From: [REDACTED]
Sent: 17 November 2020 15:51
To: Finlay Gardner <Finlay.Gardner@arun.gov.uk>
Subject: Application for extension Ref: FG/142/20/HH 22 The Poplars Ferring

RE: Planning Application FG/142/20/HH. 22 The Poplars, Ferring, BN12 5QL

EXISTING FLOOR PLAN.

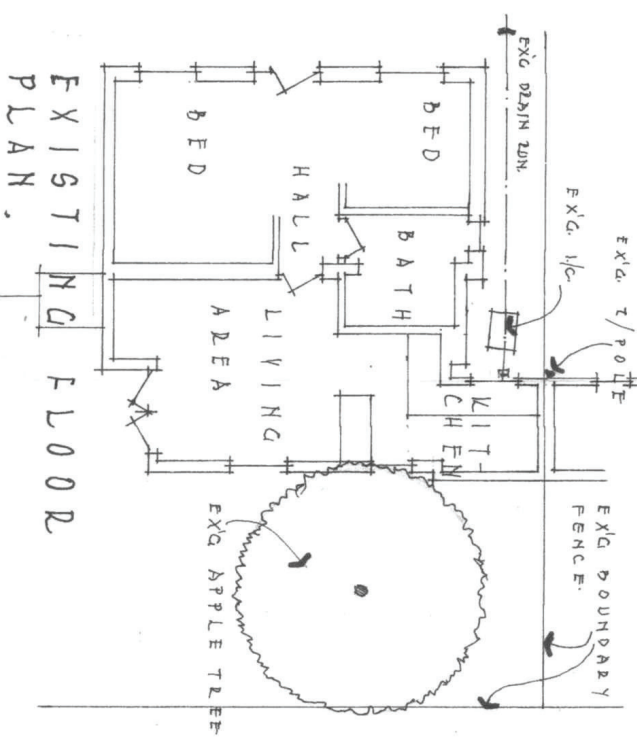
We have some grave concerns, not with the overall plan, but with the detail and how the construction work is likely to cause damage to our property. The existing plan also shows that a small corner of our property would be built over (the existing and agreed boundary is not shown correctly on the proposed plan). This we are open to negotiation/agreement on as detailed below as we have no wish to be obstructive to the development.

Our main concern is a structural one - demolishing the single skin walls of No. 22 and digging out footings for a new cavity wall as shown on the proposed plan may well damage our bathroom walls with their enclosed water pipes and tiling. We need to protect our tenant from this: putting the only bathroom out of commission for repairs would require the re-housing of our tenant. We believe it might be possible to undertake the work and minimize risk to us if the builder draws up and follows a suitable procedure agreed with building control and ourselves. We will require a Party Wall Agreement, a risk assessment and a schedule of works to be in place before work commences as well as a proposal from the builder as to how the tenant's car parked on our driveway will be protected. The builder needs to be fully insured including cover for temporary accommodation if it becomes necessary. We would also request that the builder informs us as to the start date so we can be present to witness that no damage occurs to our property.
